MEMORANDUM

TO: El Paso County
FROM: Element Engineering
DATE: October 13, 2022
SUBJECT: Town of Ramah Wastewater System Improvements – Grading and Drainage Plan

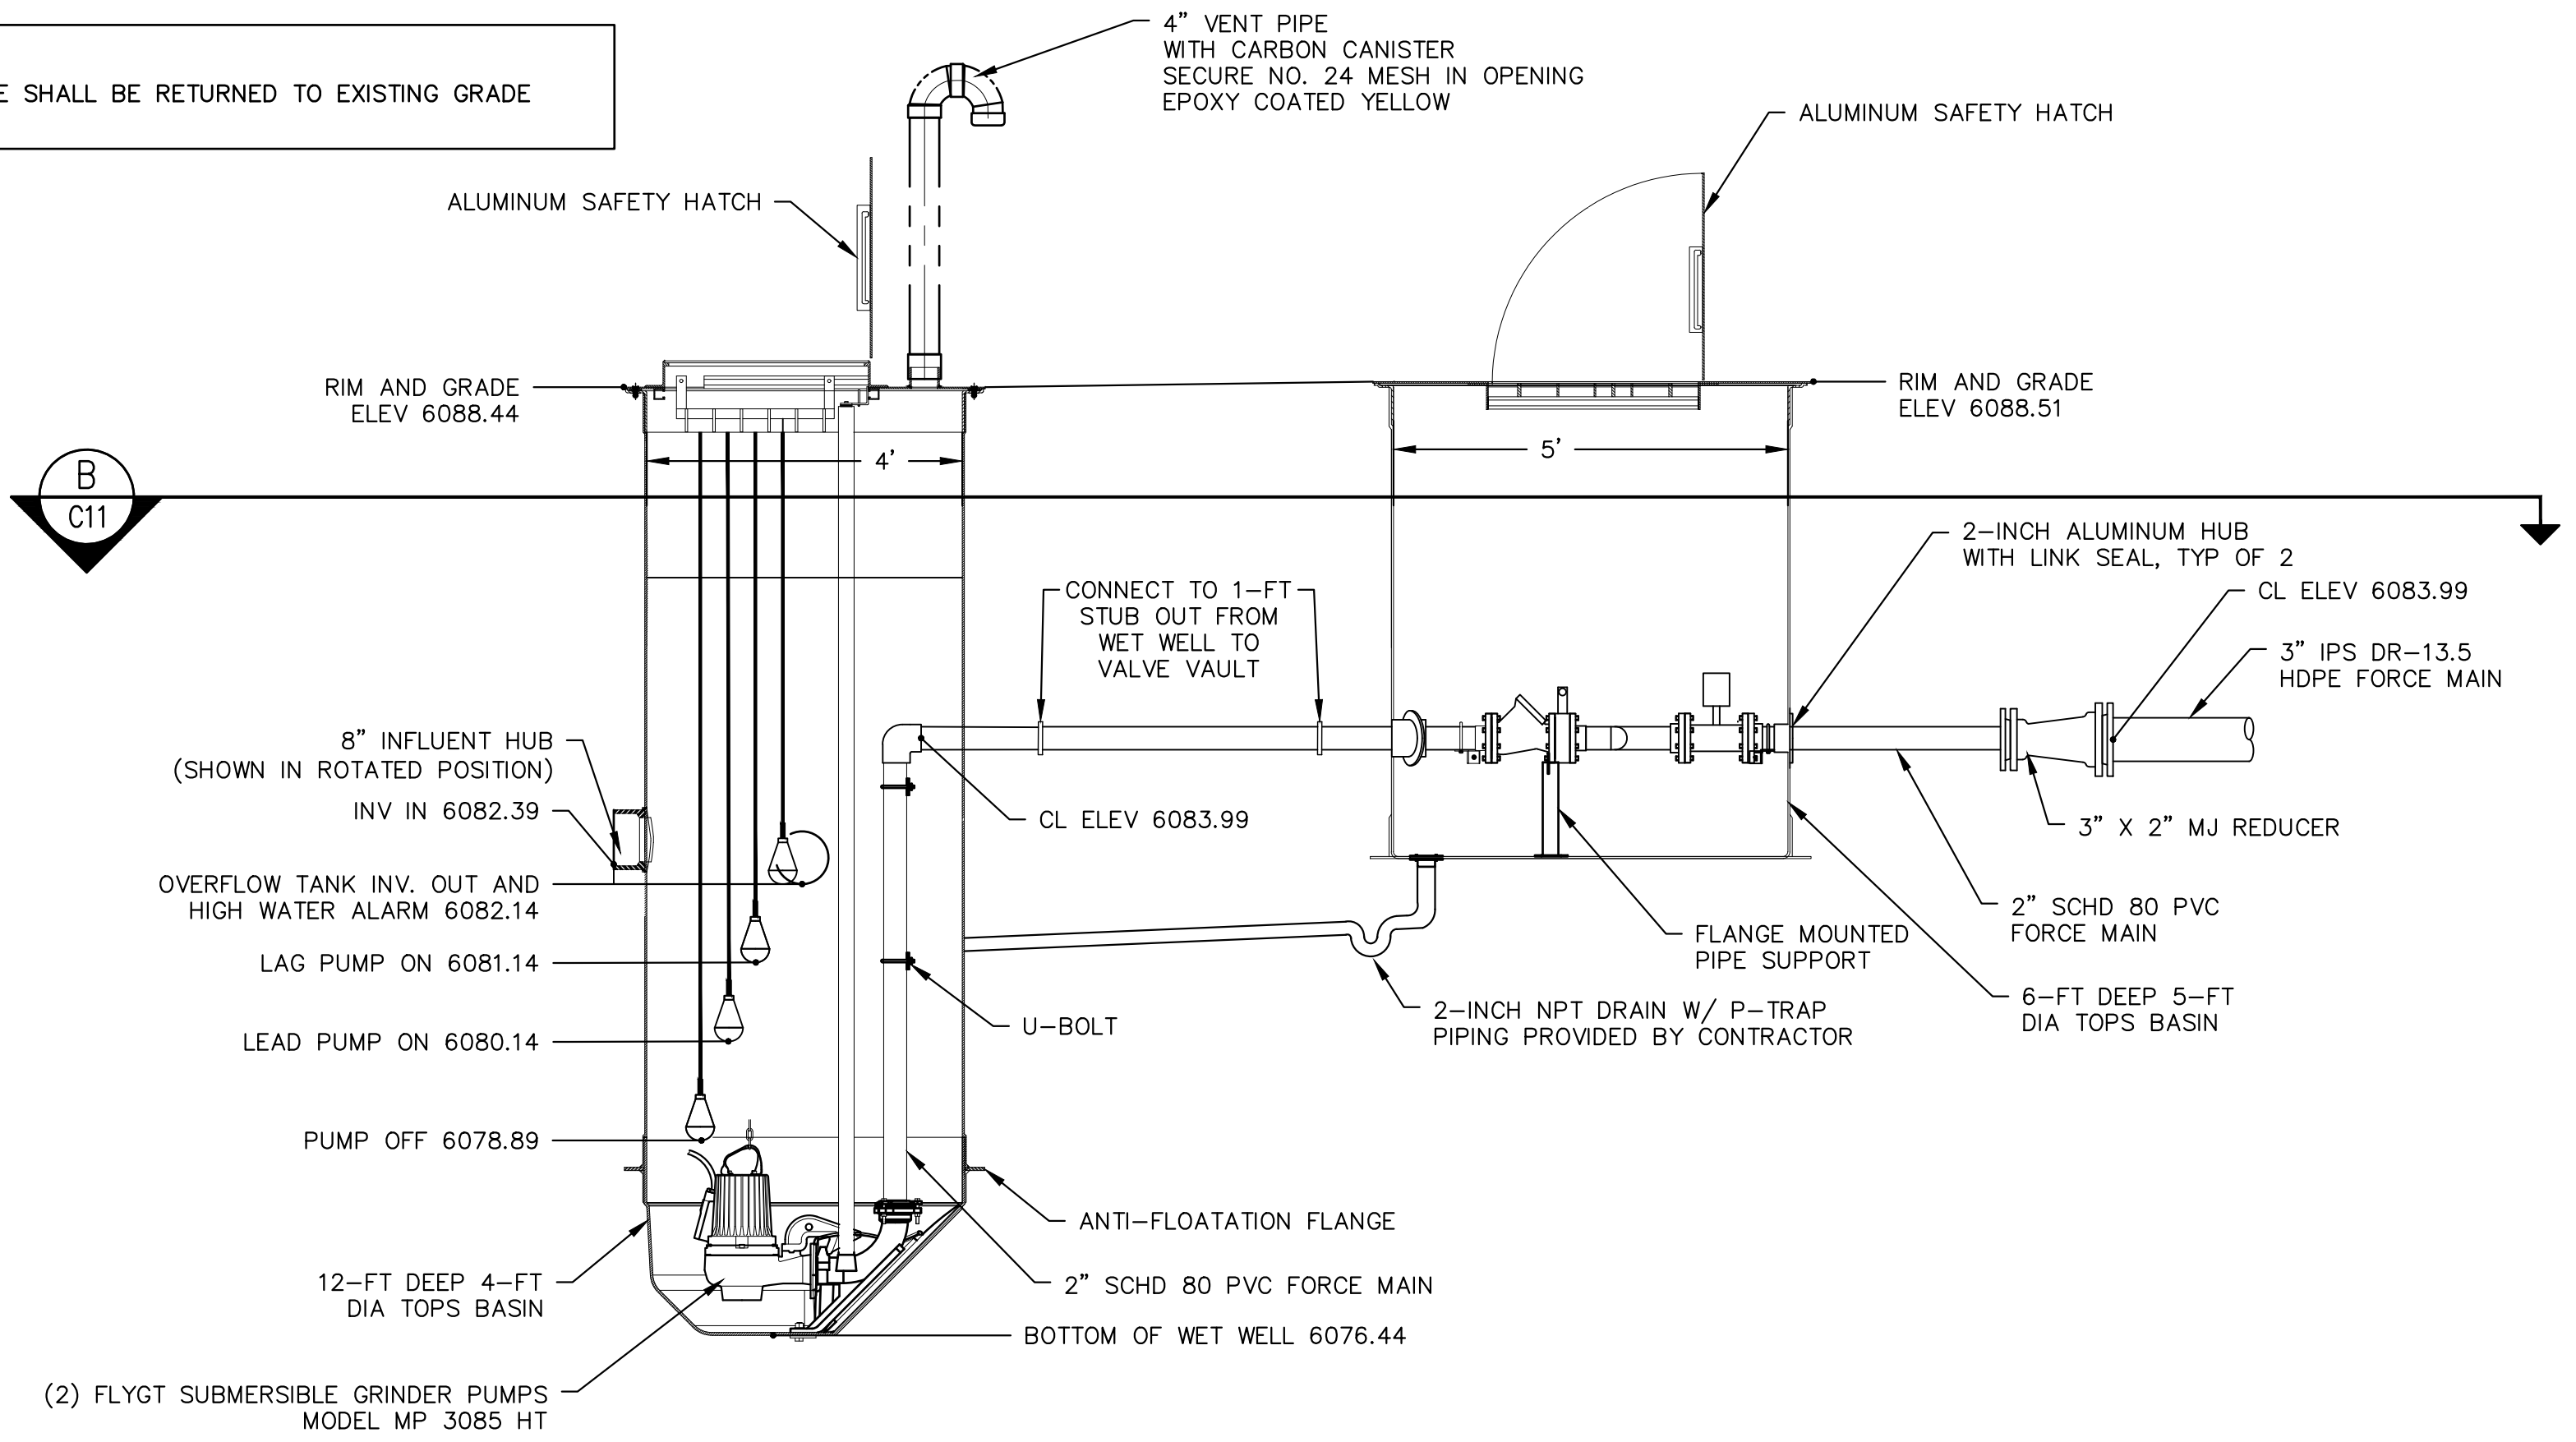
The site development plan shows a 34' x 9' concrete pad being installed. Please revise statement.

Please include dimension.

WASTEWATER TREATMENT PLANT & HORIZONTAL CONTROL & GRADING & EROSION CONTROL
 TOWN OF RAMAH - PCD FILE NO. PPR2325
 113 S. COMMERCIAL STREET
 RAMAH, CO 80832

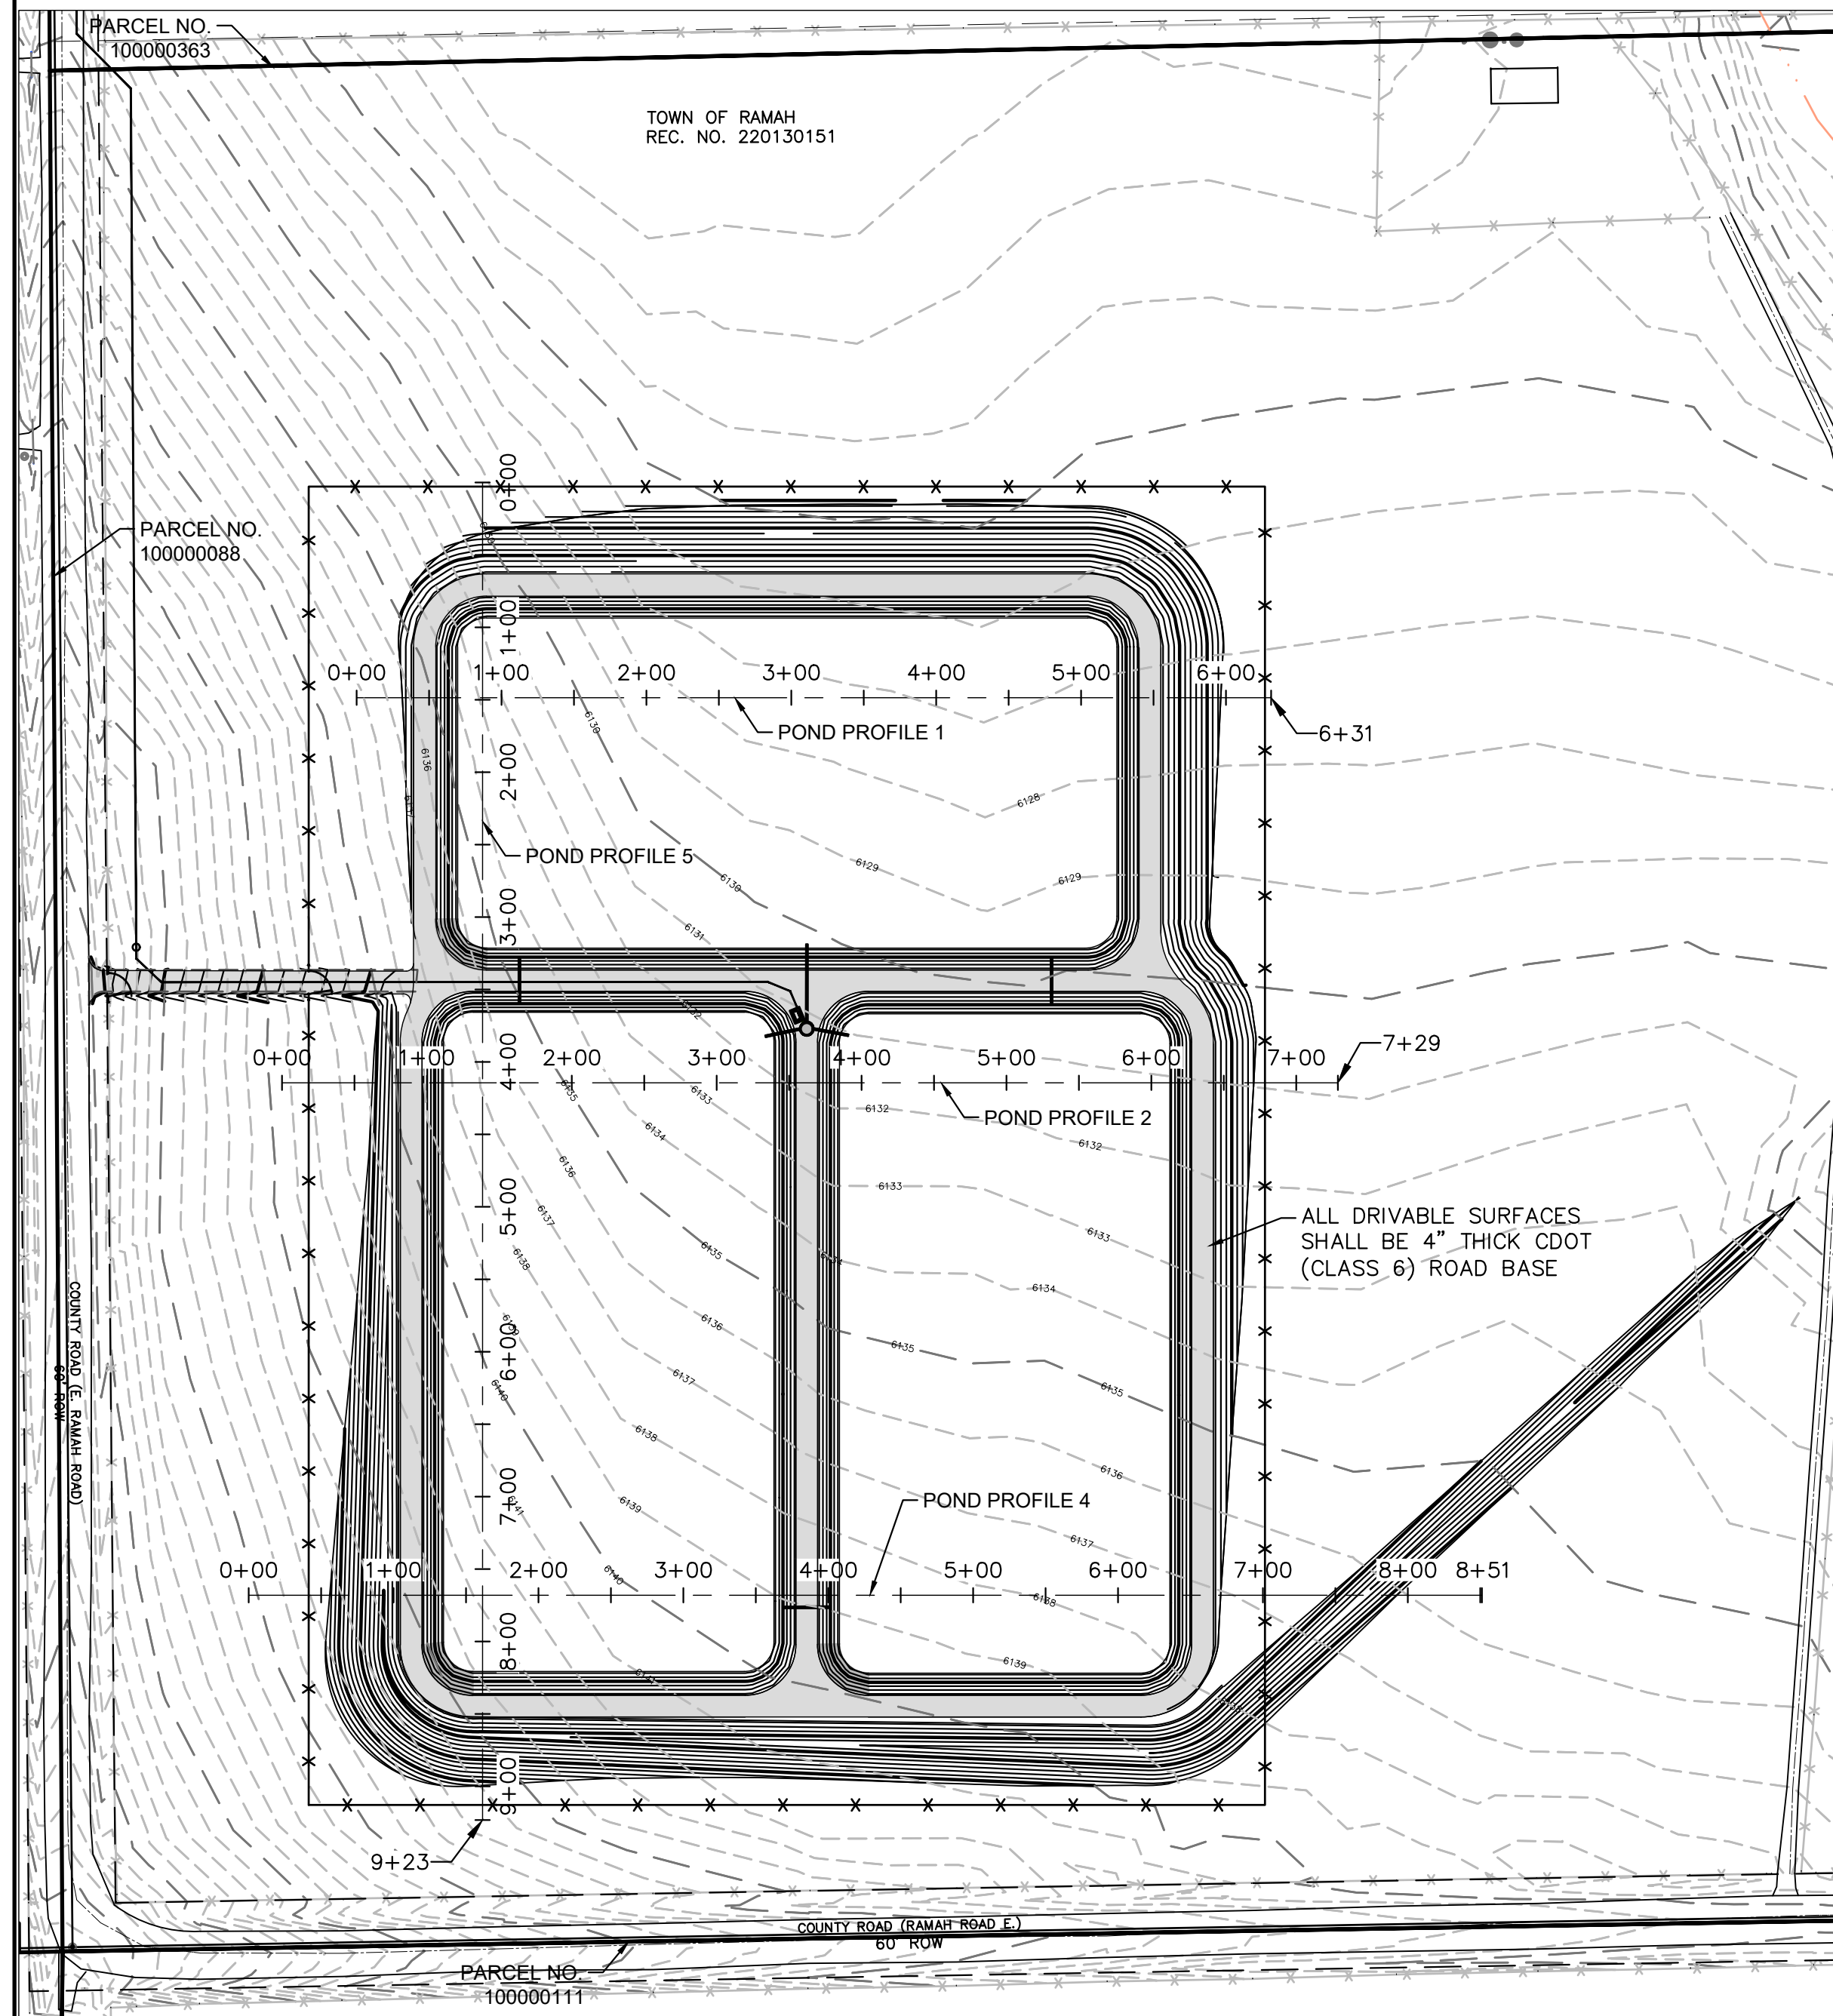
The CD's state that an existing drainage swale shall be relocated. Discuss the impacts as a result of that and document the proposed relocation. The slopes, size, and vegetation cover must be equivalent and sufficient to convey the runoff and not impact the lift station or road.

Show contours and location of existing swale before and after proposed relocation

WASTEWATER TREATMENT PLANT
CUT & FILL PLAN
 TOWN OF RAMAH - PCD FILE NO. PPR2325
 113 S. COMMERCIAL STREET
 RAMAH, CO 80852

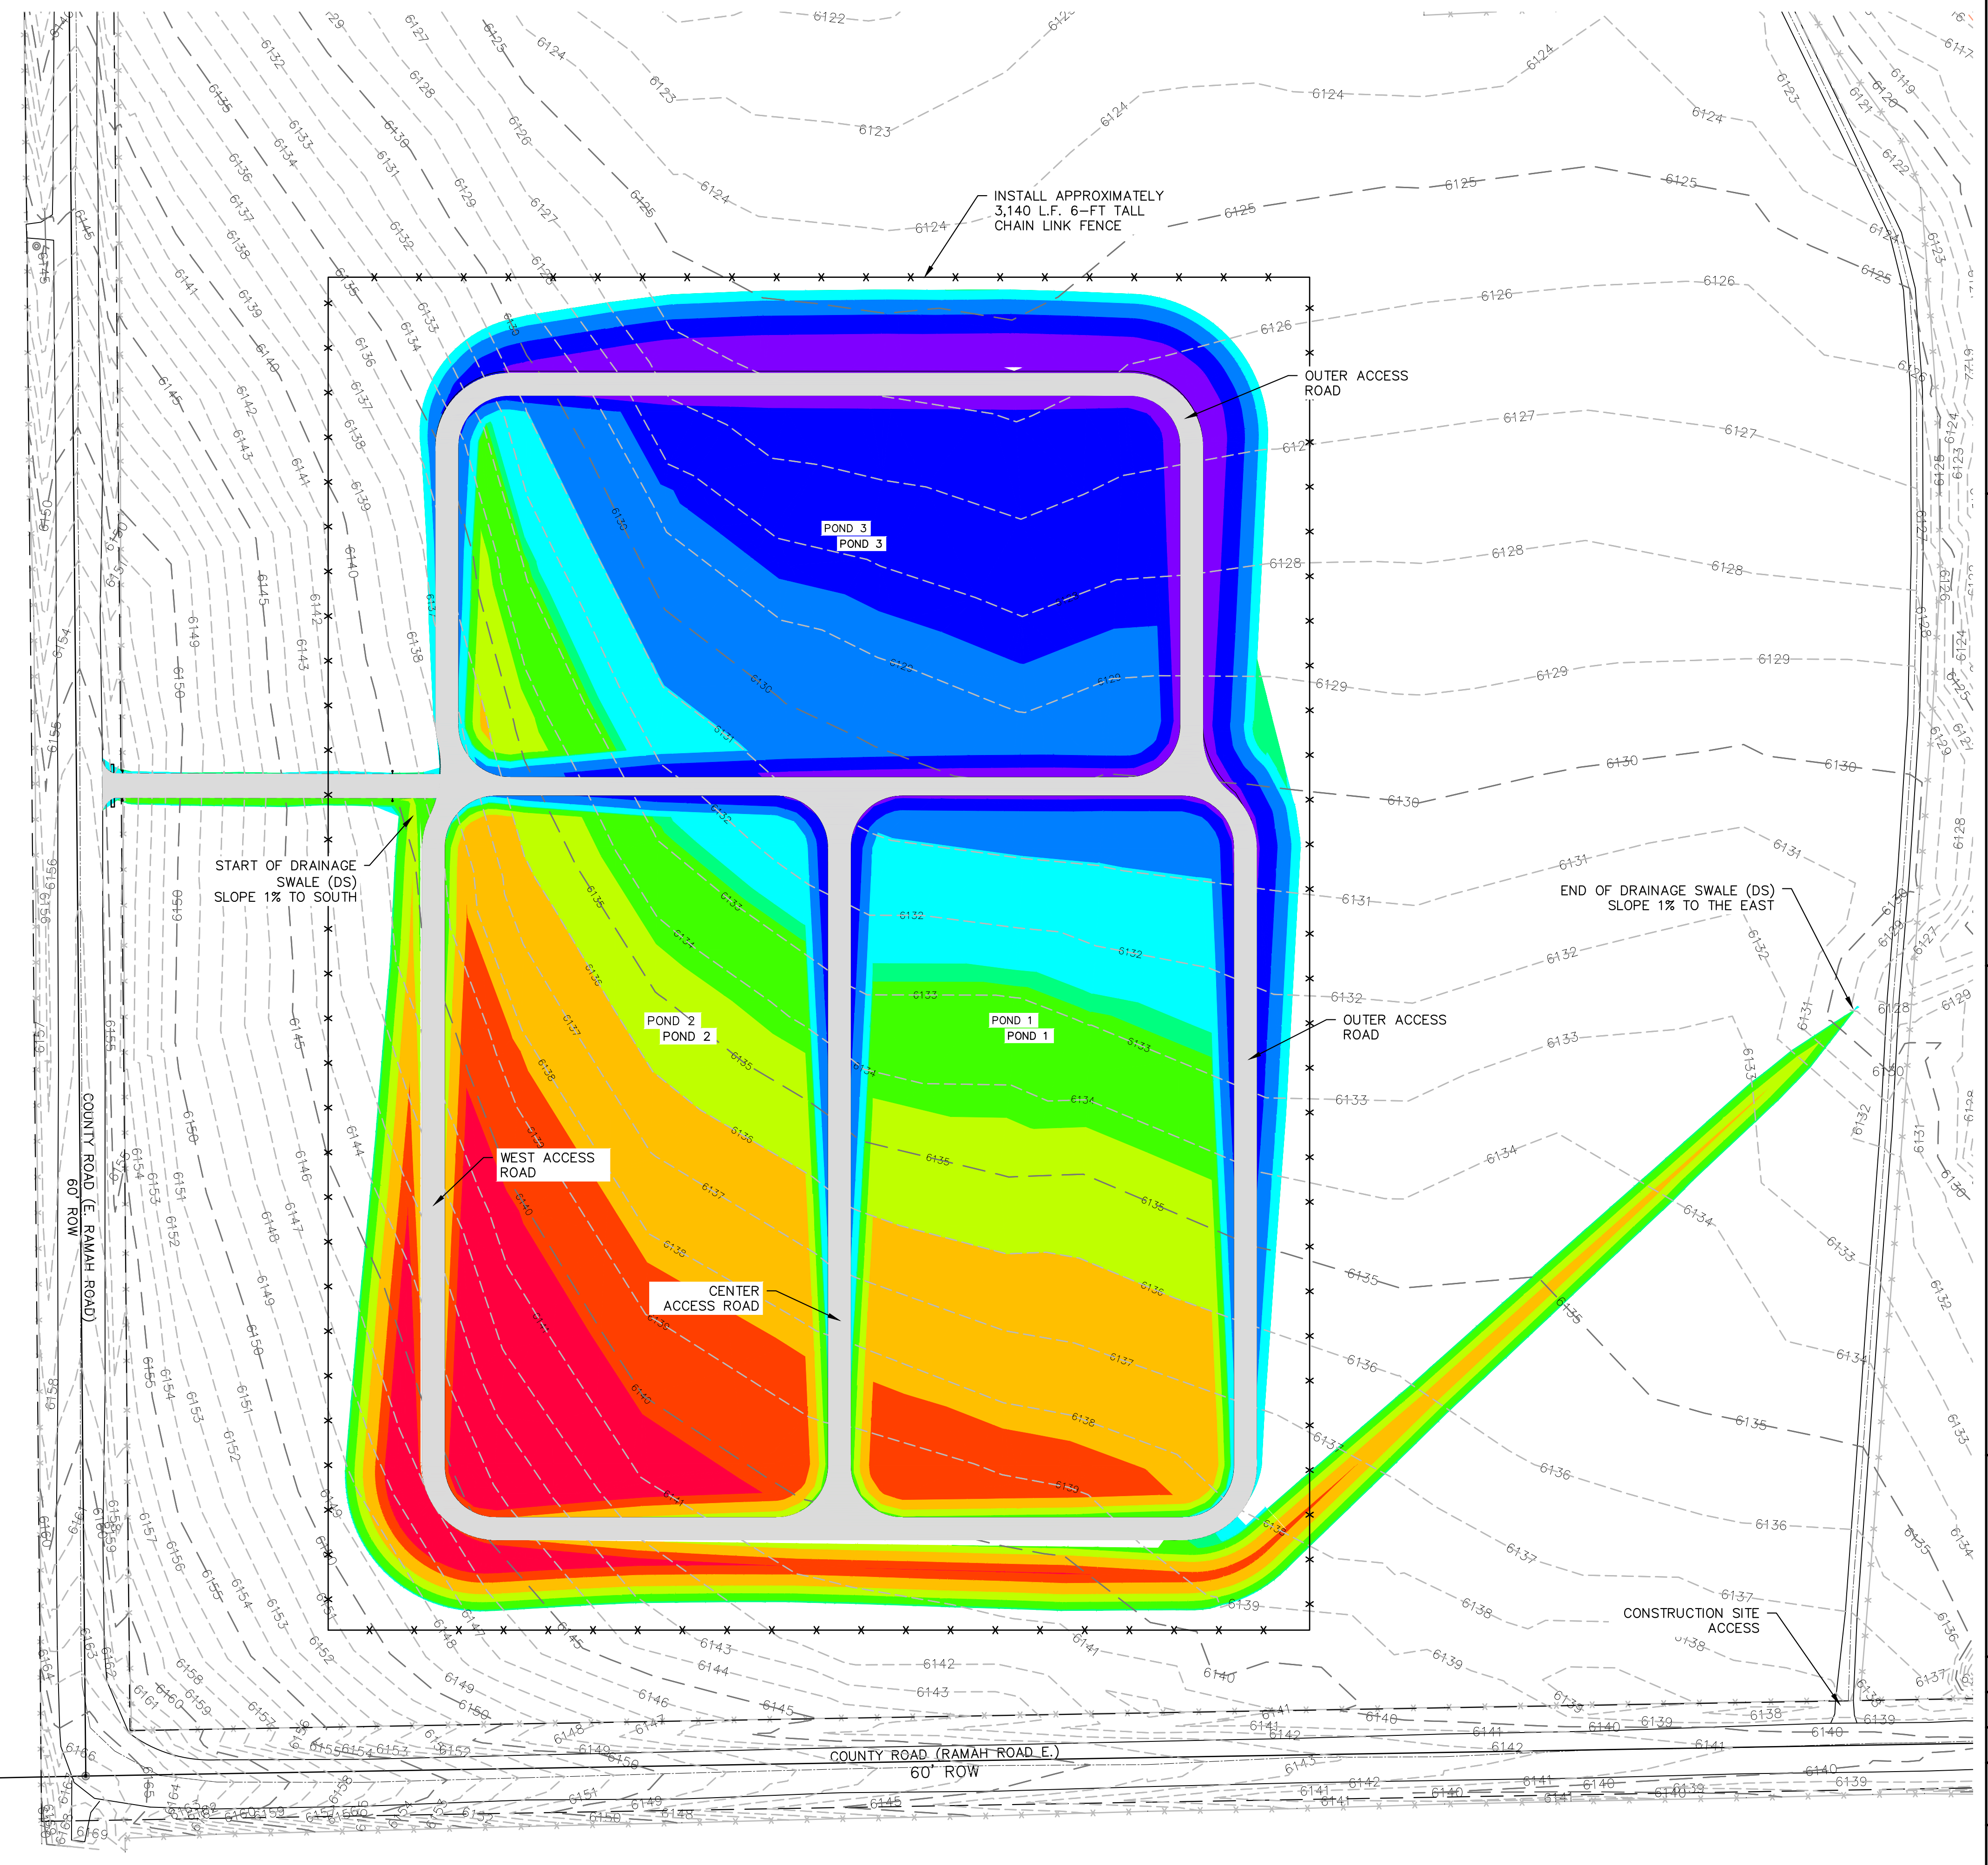
Cut and fill quantities do not match with what is shown on the CD set. Please verify quantities and update accordingly.
